An Coimisiún Pleanála

Case Reference: PAX92.324370

Re: Proposed Littleton Wind Farm, County Tipperary – Submission/Objection

ZTV indicating the cumulative theoretical visibility of the proposed Littleton Wind Farm in combination with existing cumulative scenario

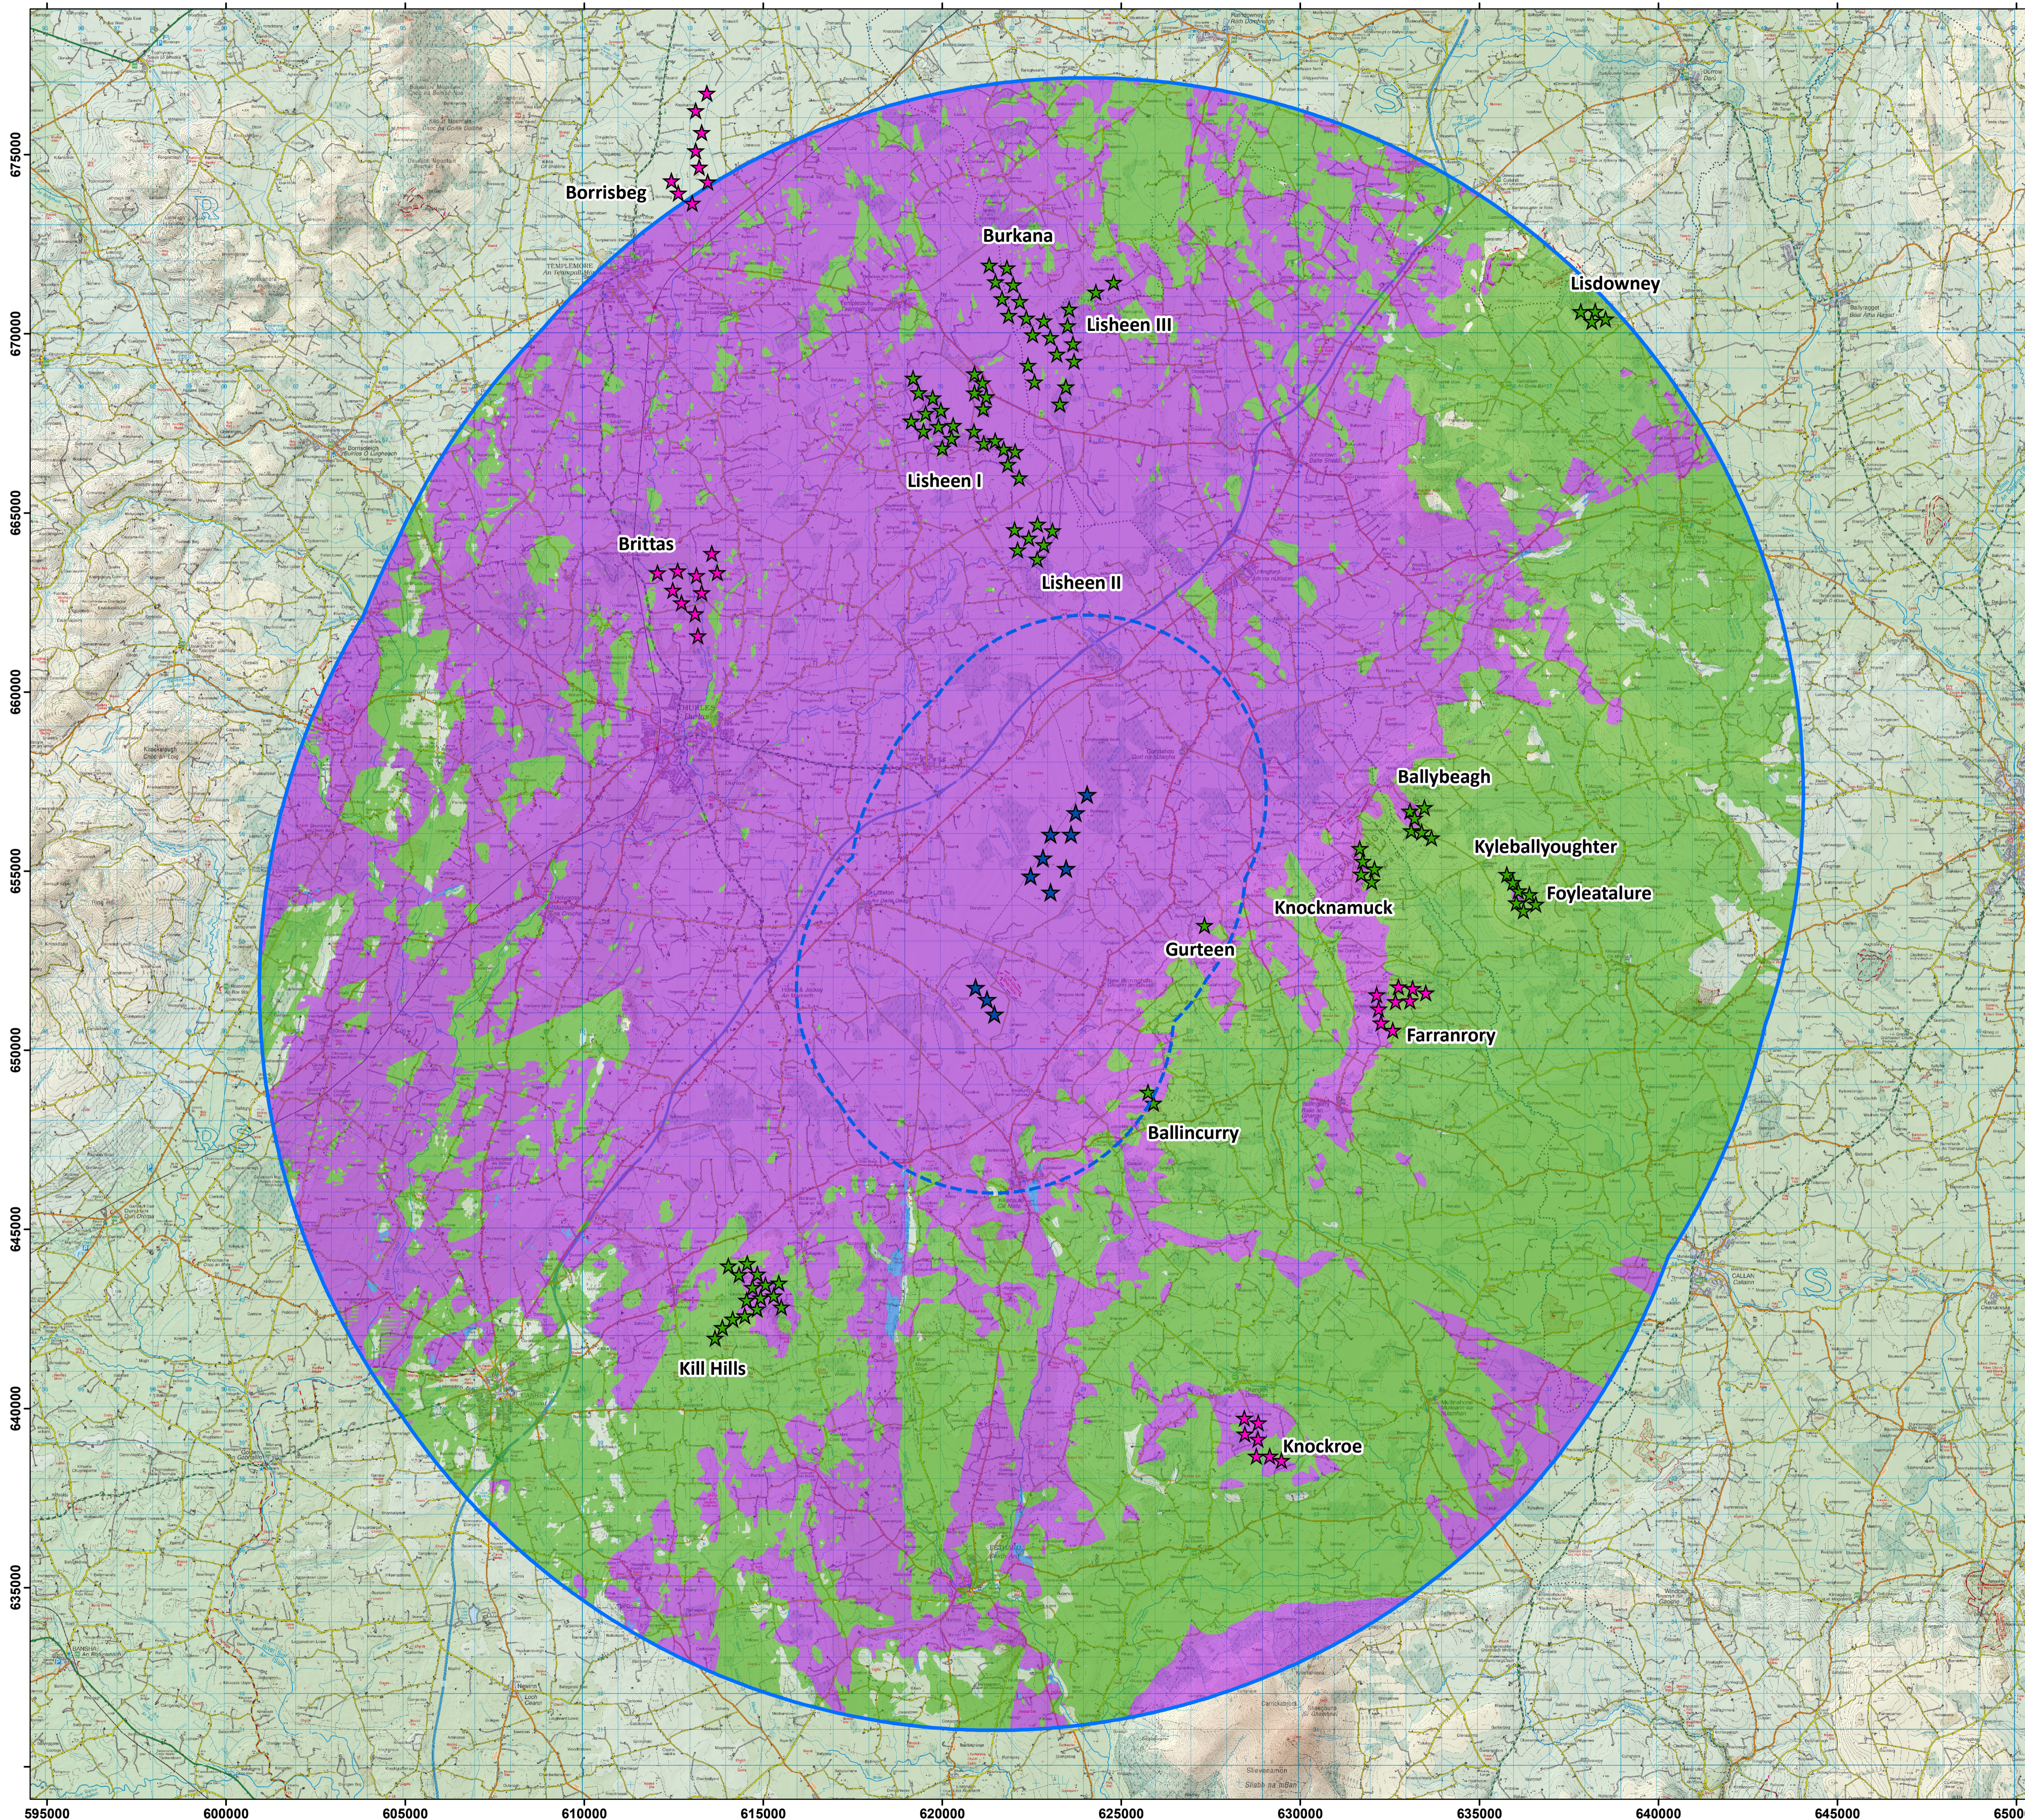
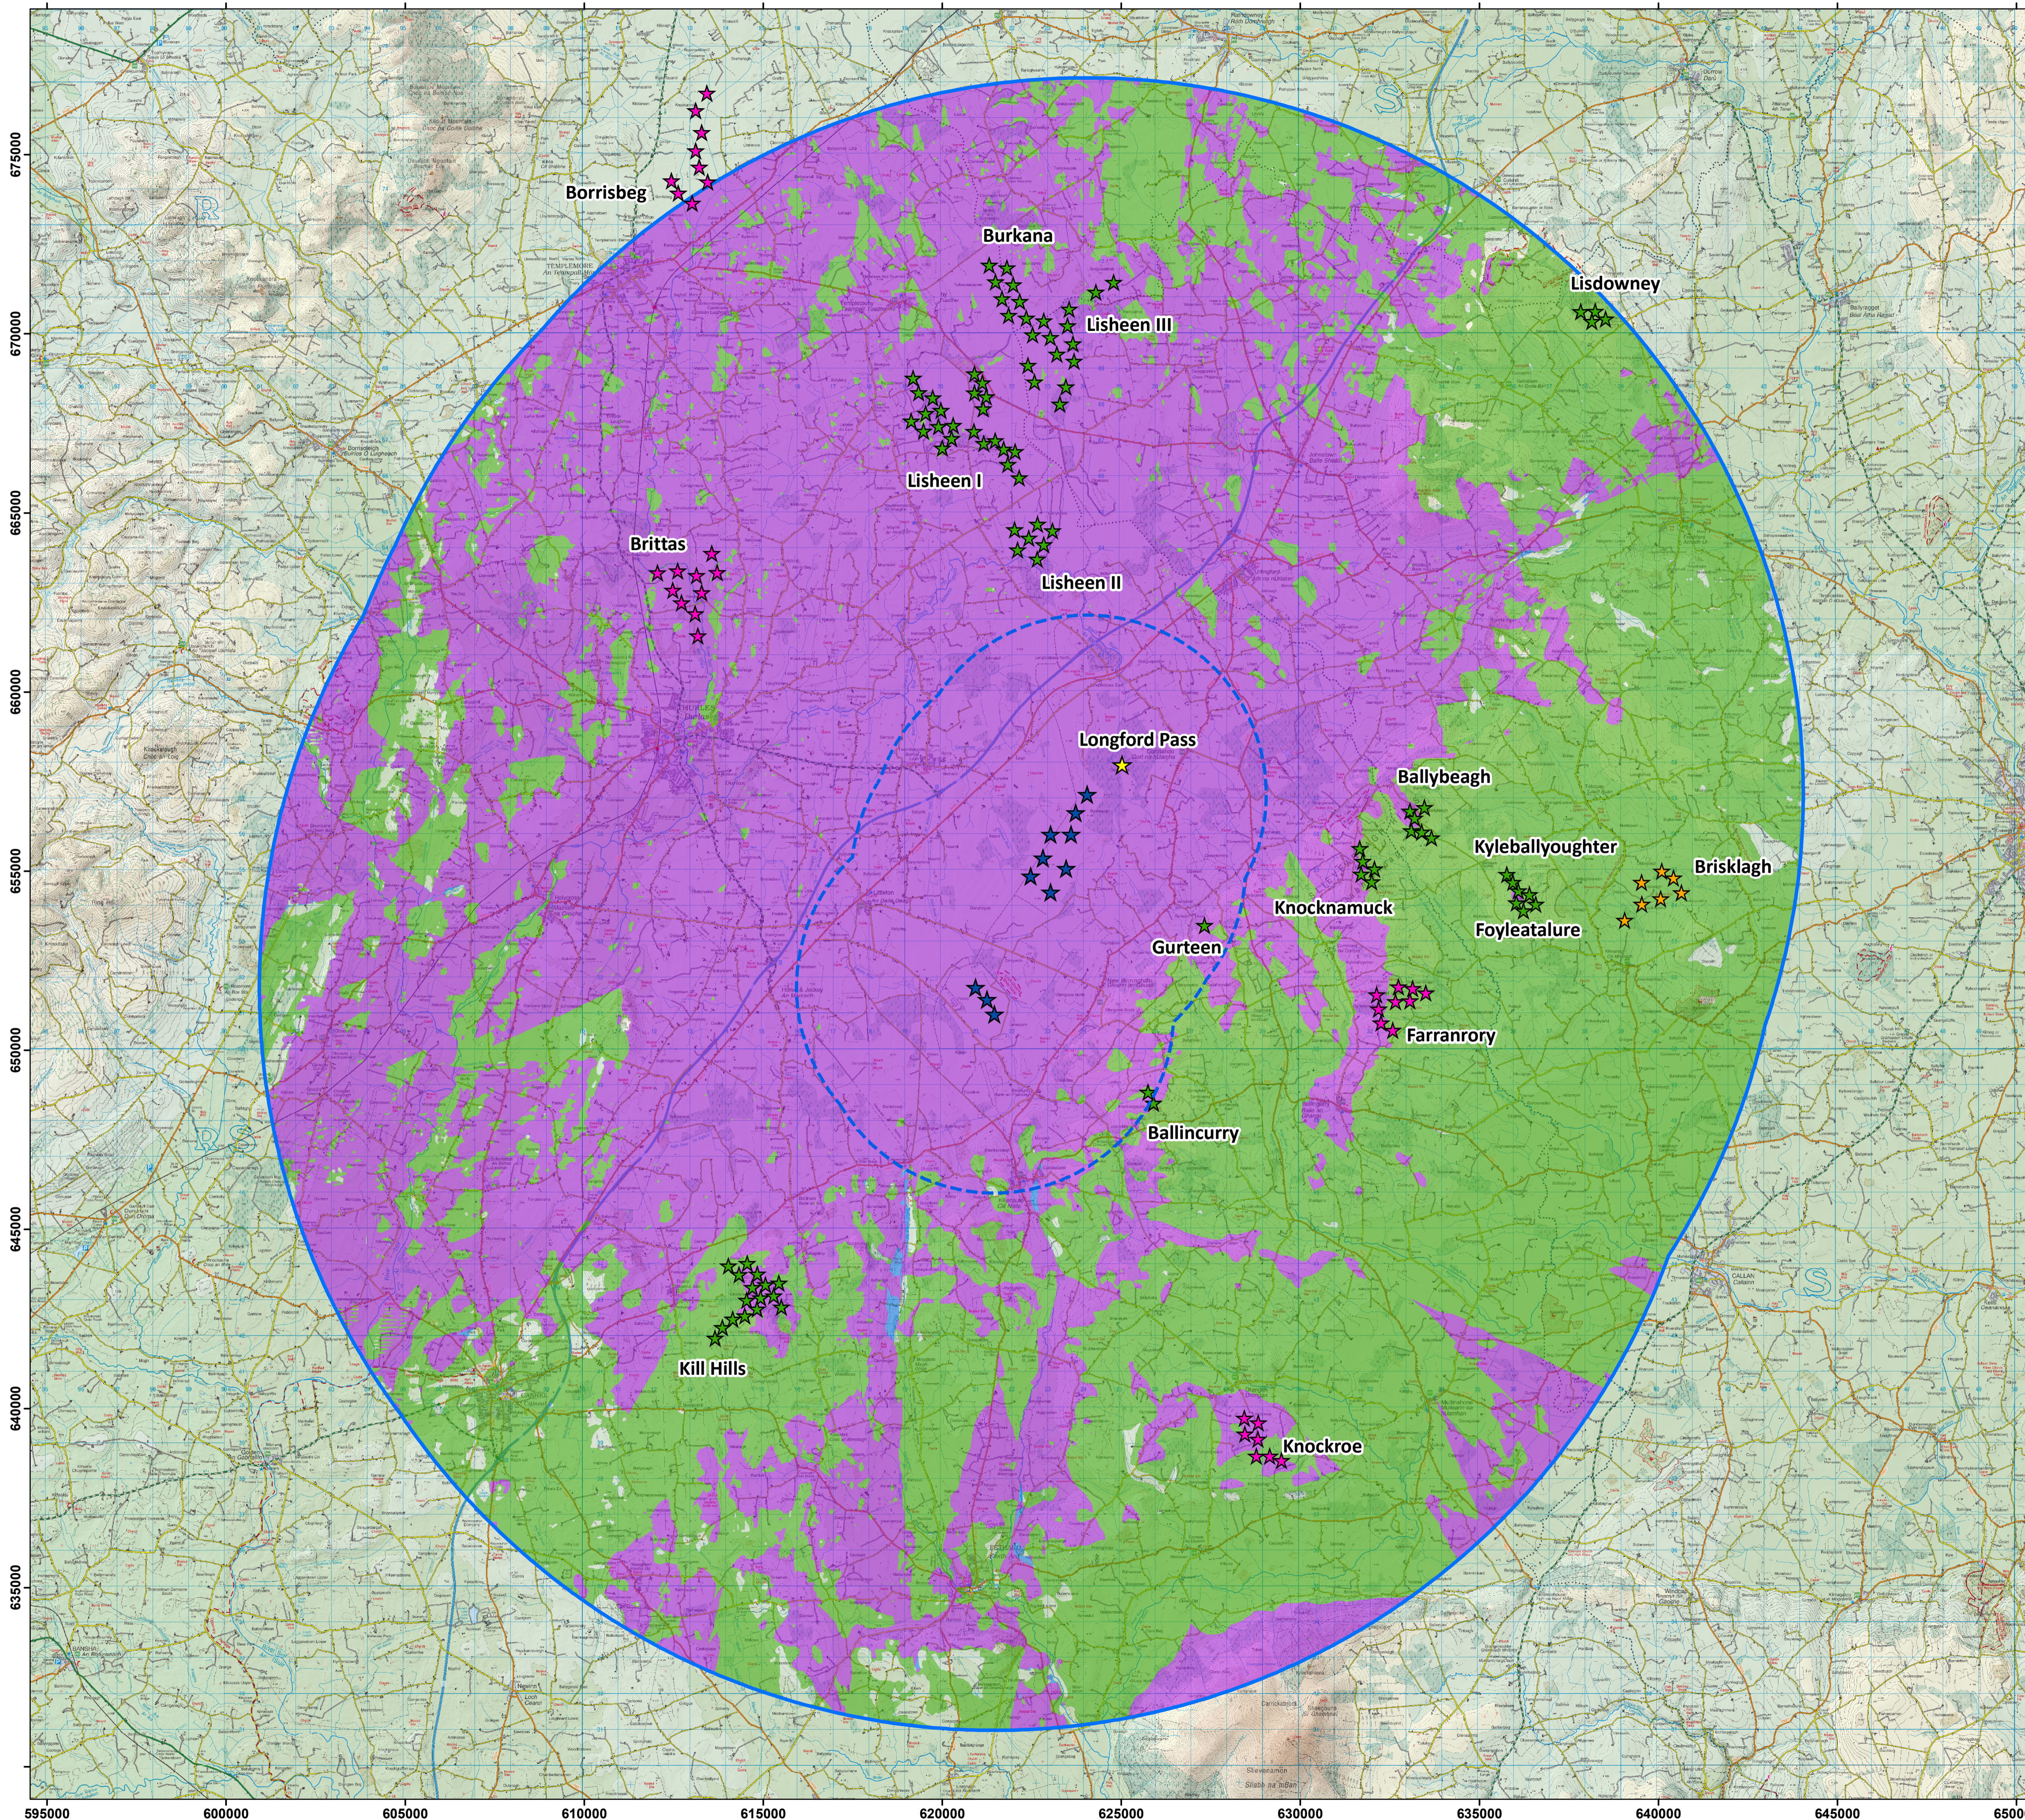
The applicant's cumulative Zone of Theoretical Visibility indicates that approximately **56.6% of the study area has the potential for combined views** of the proposed Littleton development and existing or consented wind-energy developments.

The existence of other turbines should not automatically be regarded as reducing the significance of adding a further 11 turbines of approximately 200 metres in height.

The applicant's cumulative assessment relies significantly upon Zone of Theoretical Visibility modelling and consideration of screening from vegetation and other landscape features.

I ask the Board to scrutinise this methodology carefully.

Vegetation is not a permanent or reliable visual barrier. Trees and hedgerows change with the seasons, can be removed or managed, and provide limited screening for structures approximately 200 metres high.

The fact that lower portions of turbines may be screened does not necessarily prevent the upper portions from remaining prominent within the landscape.

<b>TITLE:</b>	Windfarms within 20km
<b>PROJECT:</b>	Littleton Windfarm
<b>FIGURE NO.:</b>	4.6
<b>CLIENT:</b>	Littleton Wind Farm DAC
<b>SCALE:</b> 1:200,000	<b>REVISION:</b> 0
<b>DATE:</b> 30/04/2026	<b>PAGE SIZE:</b> A3

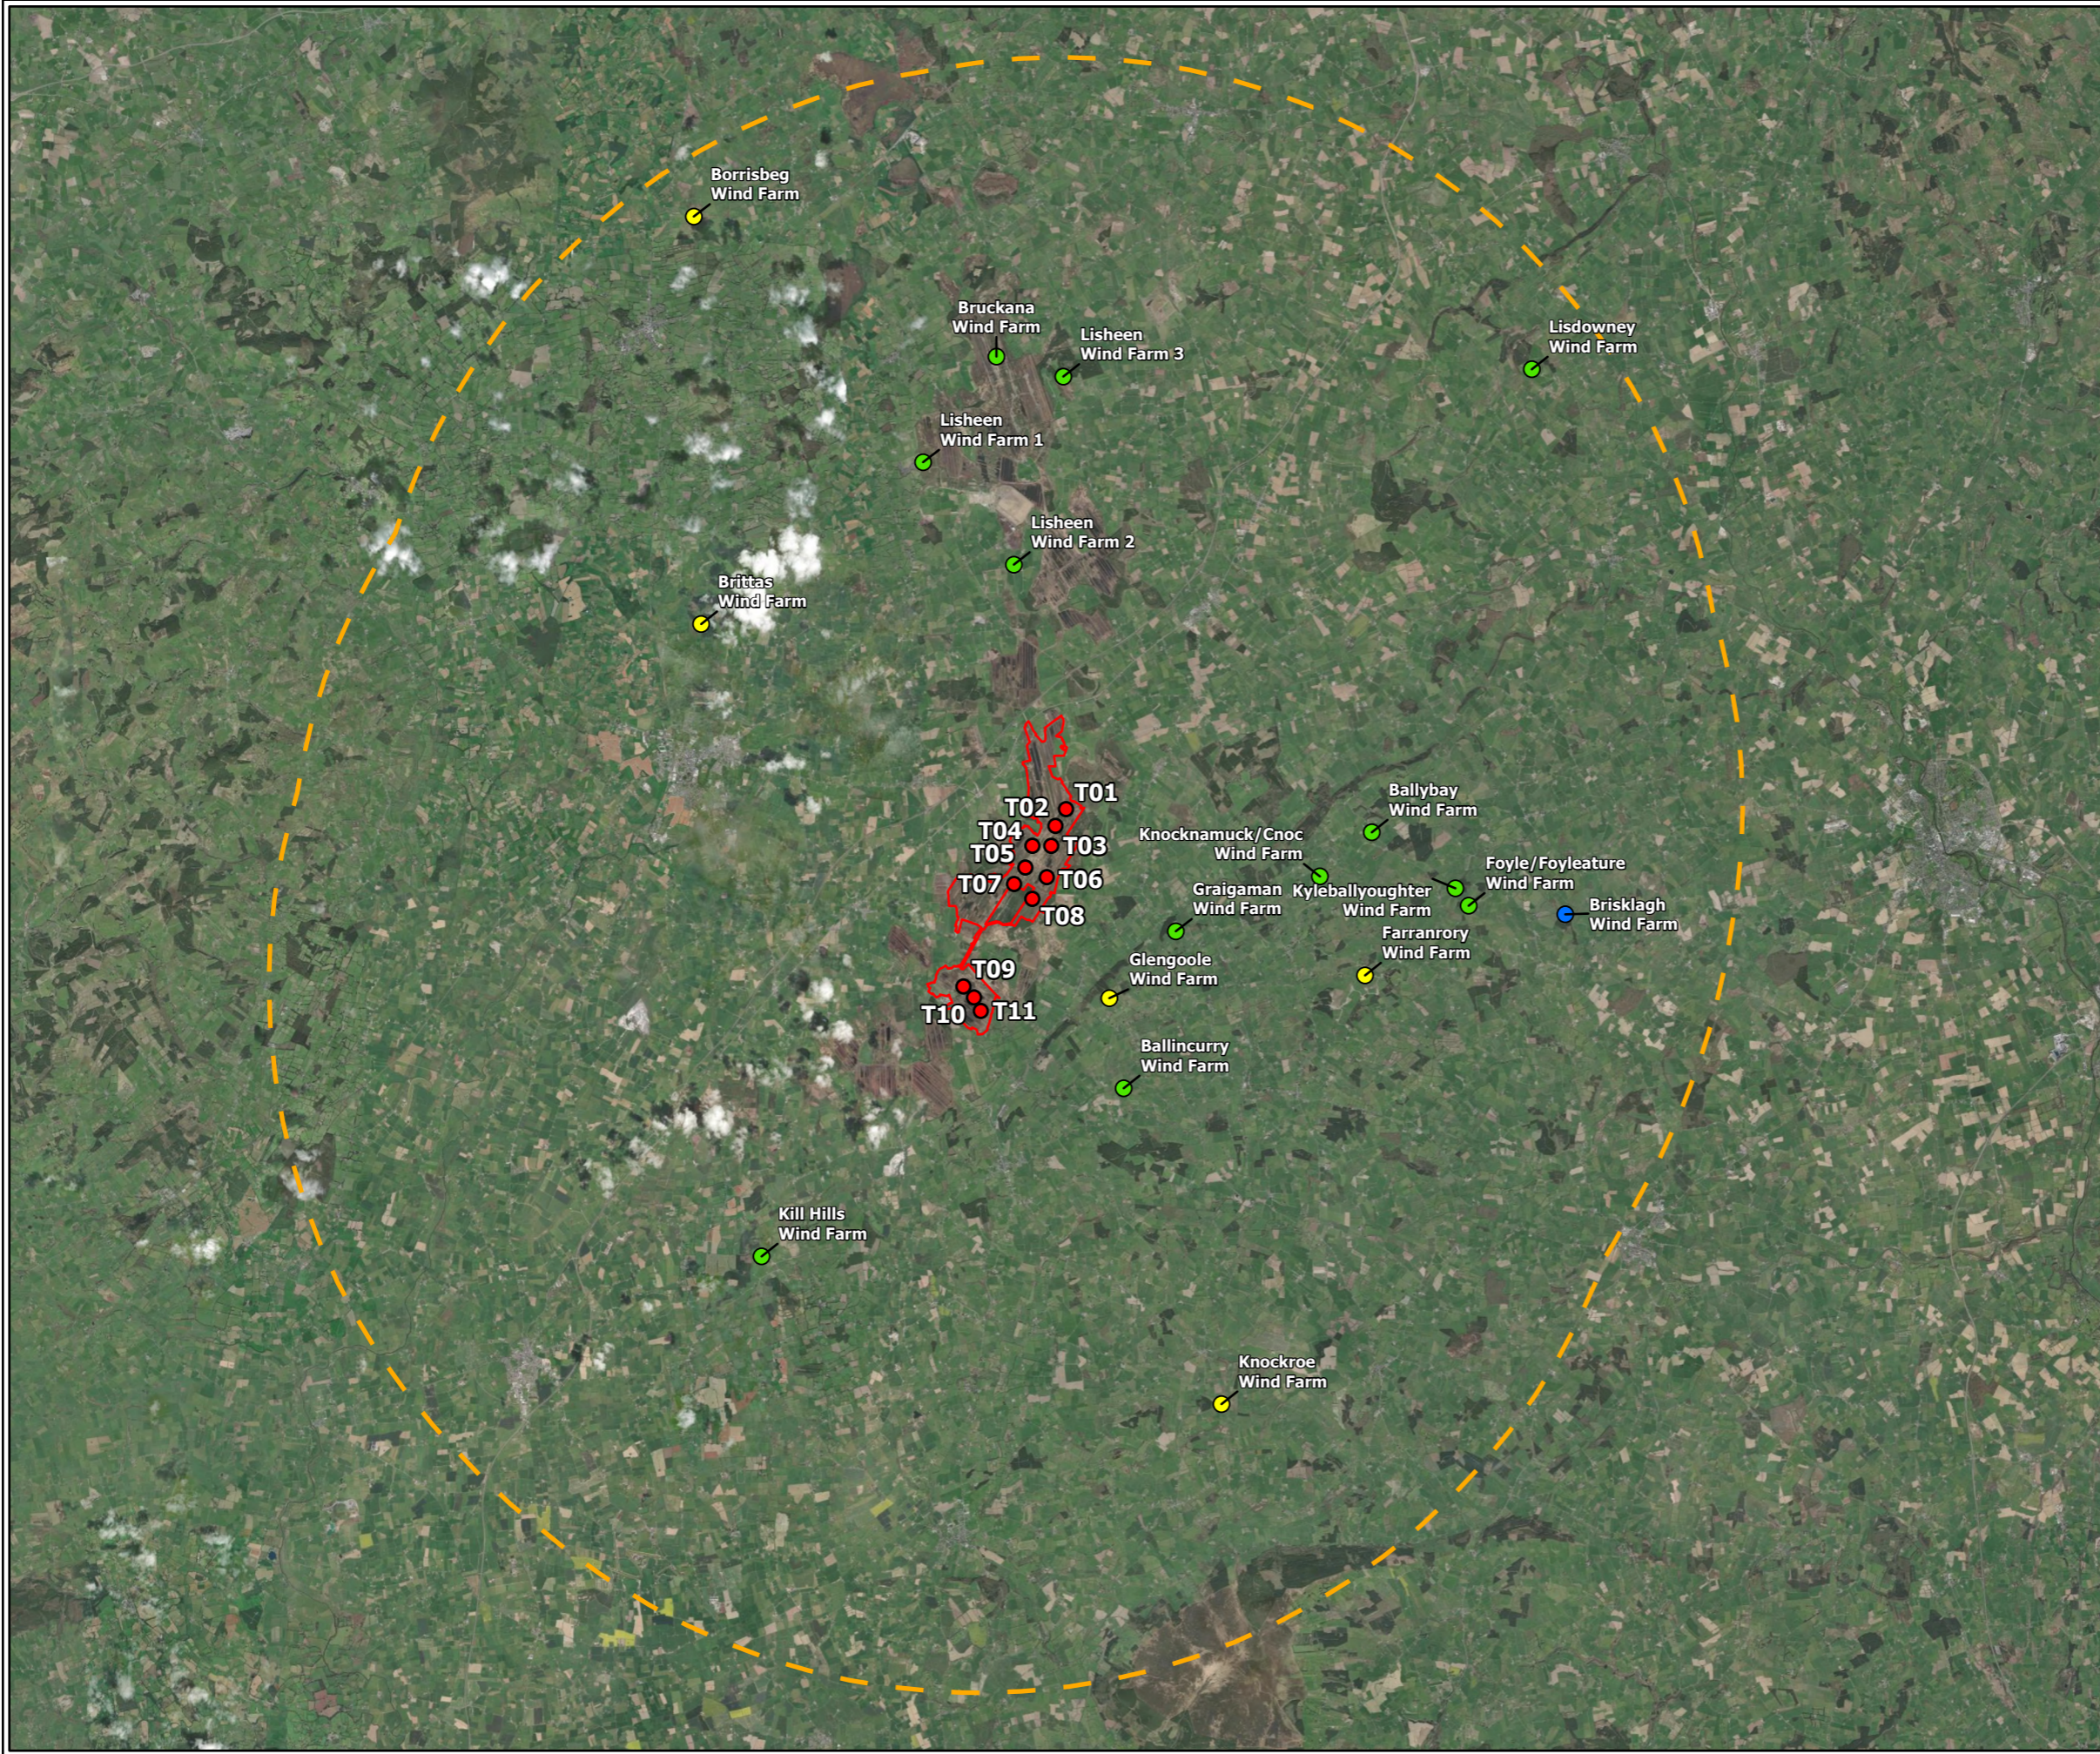
The applicant identifies approximately **128 existing and consented turbines within 20 kilometres** of the proposed development.

The applicant's own assessment identifies approximately **128 existing and consented turbines within 20 kilometres**.

If each individual development is considered principally on its own merits, there is a risk that the cumulative effect of successive projects becomes significant only after the landscape has already been substantially transformed.
